Subject: RE: DA 485-12-2002 MOD 1 - S75W Modification - Nadine Street, Sanctuary Point

I refer to SCC's letter dated 5 January containing a number of additional matters to the proposed additional information submitted with our s75W application.

REV	DESCRIPTION	BY	DATE	RATIO: 1:1000 (AT A3 ORIGINAL)		DATE OF PLAN: 06.09.2016
				DRAWING NUMBER 26522-03	SHEET 1 OF 1	REVISION P0

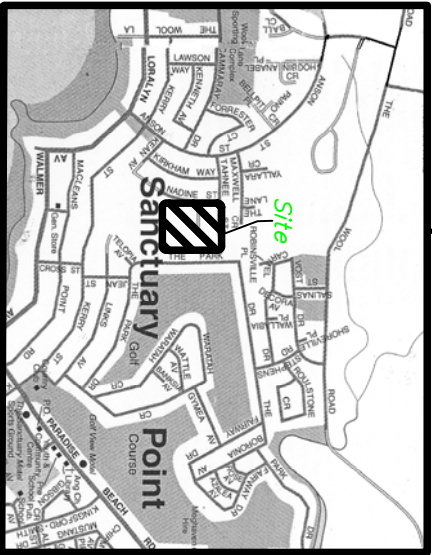
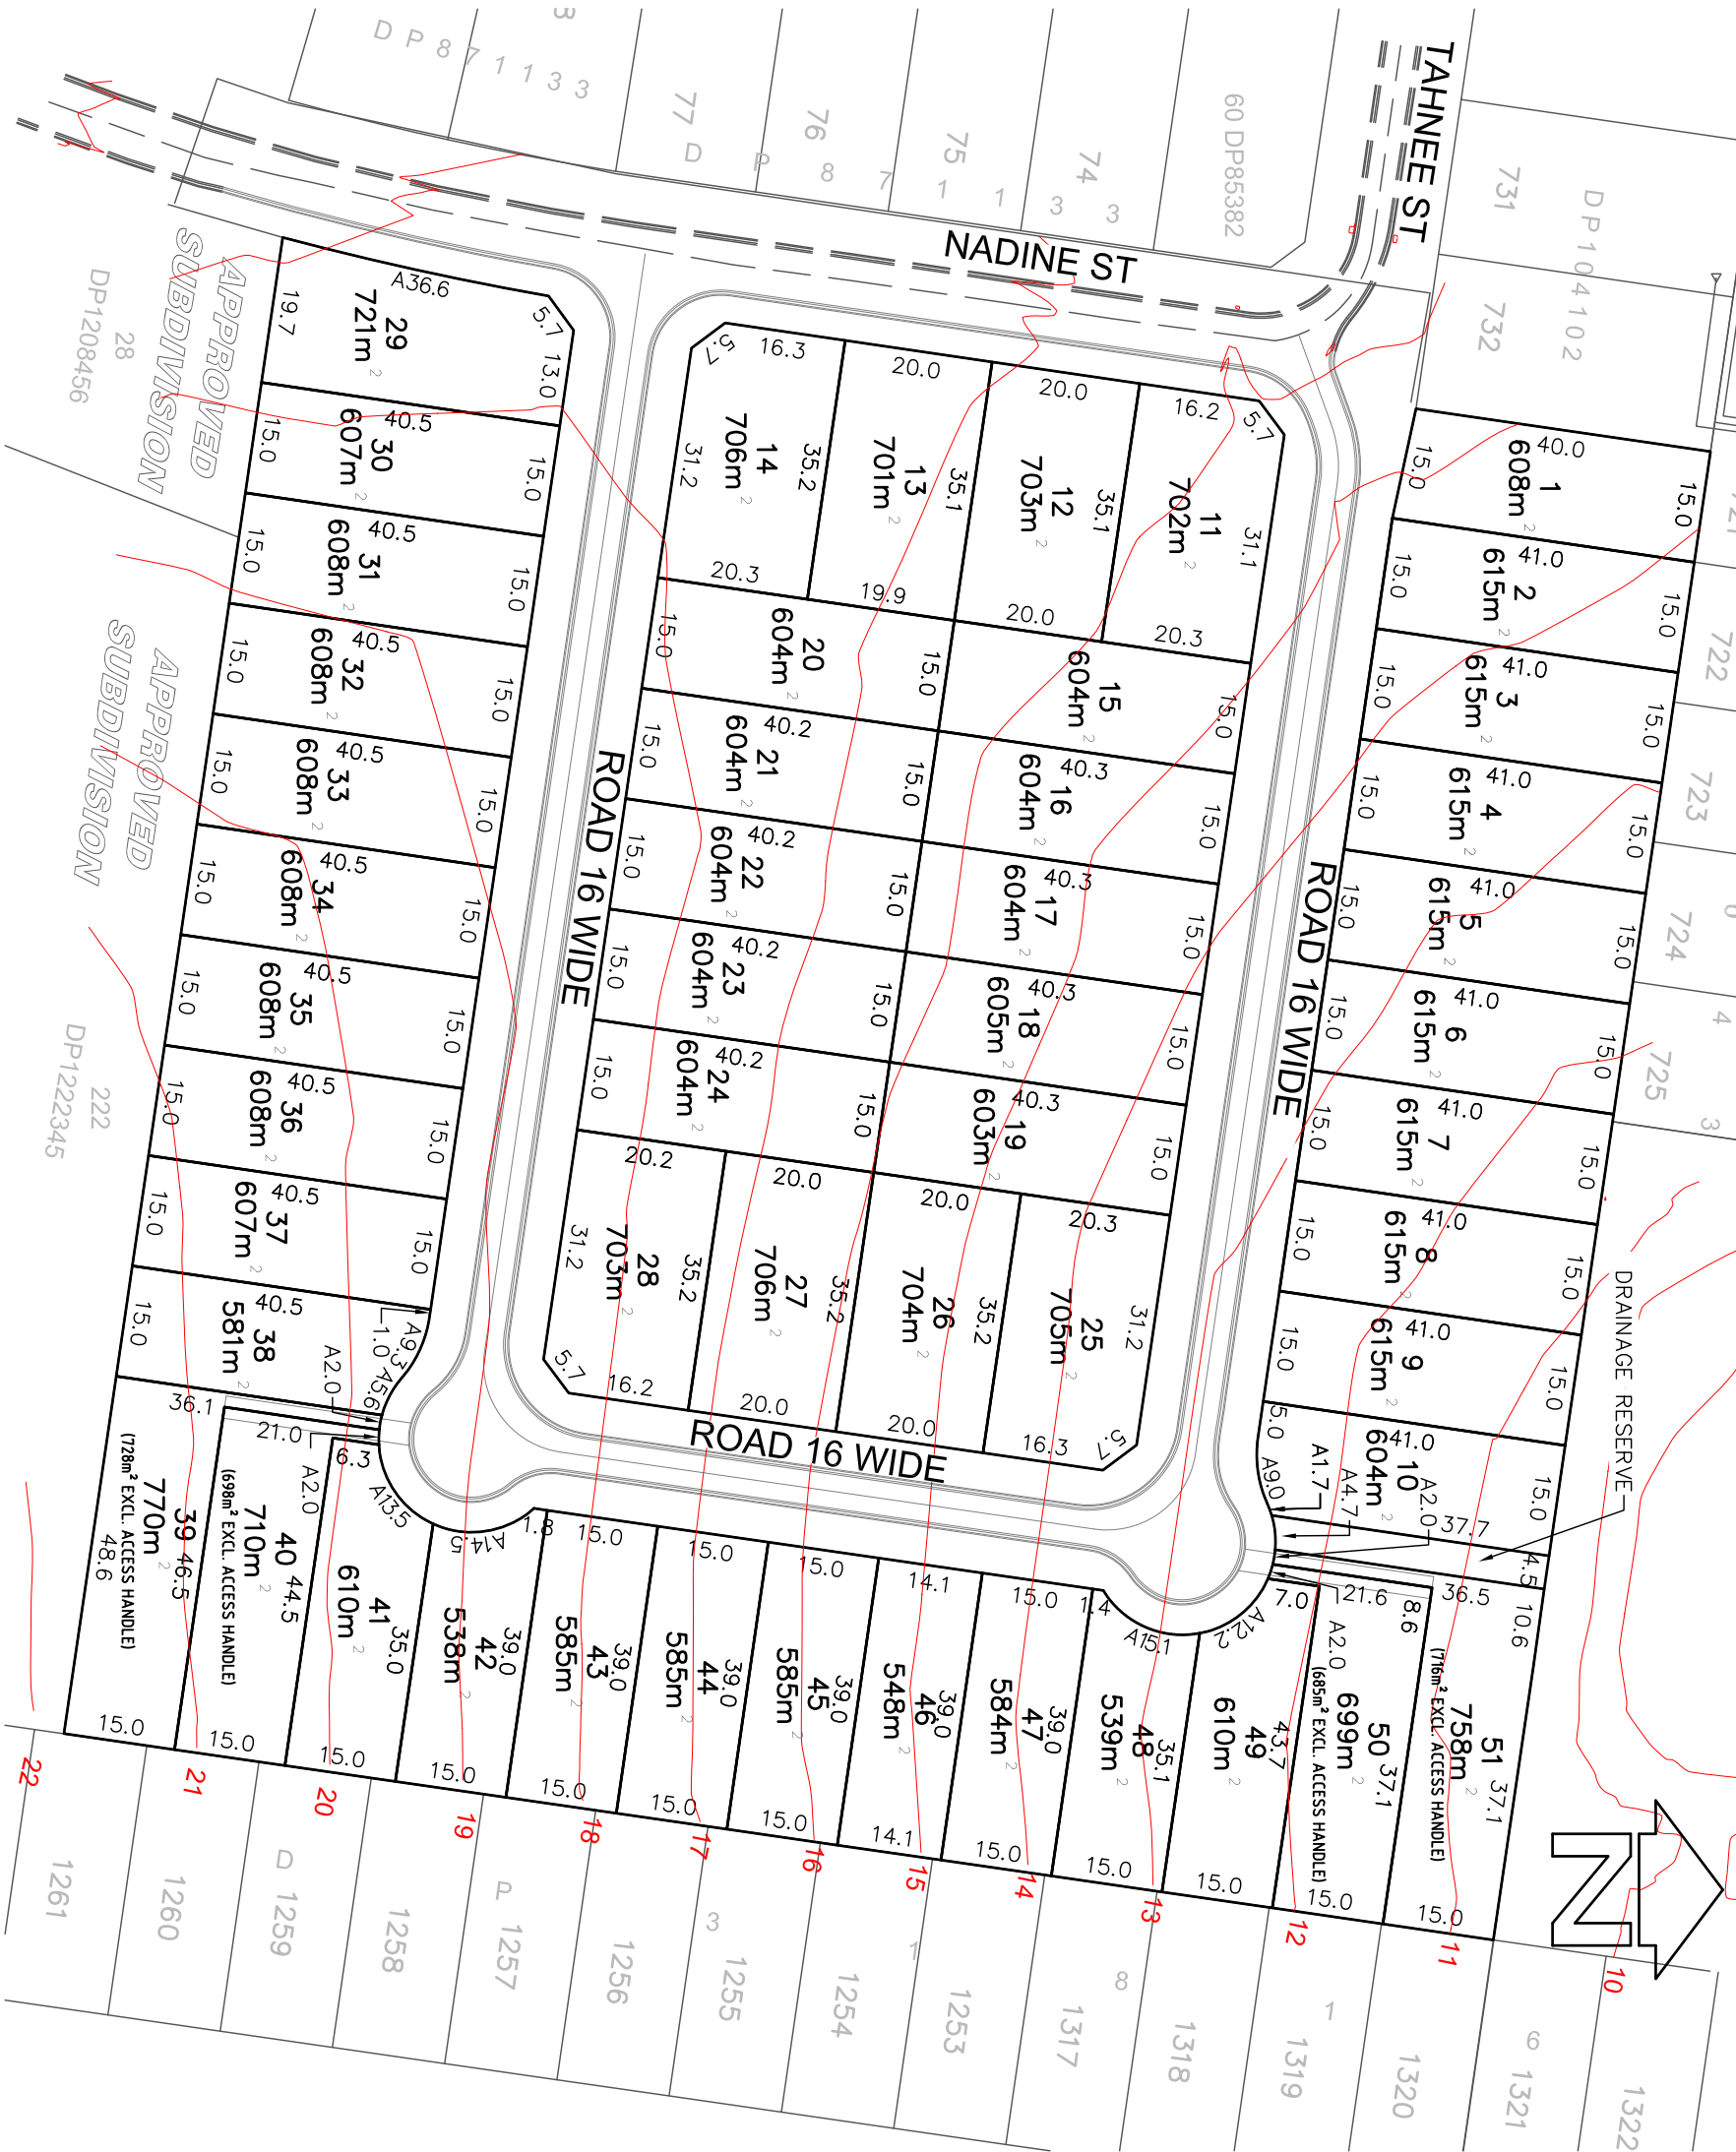
SCC is concerned about 7 x east-west orientated allotments that are 15.0m wide and states that the concerns raised by SCC have not been addressed.

SCC is concerned about medium density development on consolidated corner allotments.

The attached "Solar Access for Lots Guide" for NSW Subdivisions requires lots to have sufficient space to contain the required solar access zones. The proposed east-west lots have slope to the north of approximately 6% or 3 degrees and therefore contain sufficient width and length to accommodate the required solar access zones for both single storey and double storey dwellings located to the north.

SCC does not have justified concerns about solar access to 15m wide east-west allotments, particularly ones that slope to the north as they do on this particular site, which opens up solar access.

Medium density development on any allotment does not form part of this proposal.

The width of the proposed road reserve are now shown on the attached plan being APS drawing 26522-03 Rev 02 so that SCC can be certain of what is proposed.

Road widths are 16m internally with a 5m wide pavement (as per condition B2(a) of the consent) with Nadine St being 18m wide with a 7m wide pavement (as per condition B2(f) of the consent).
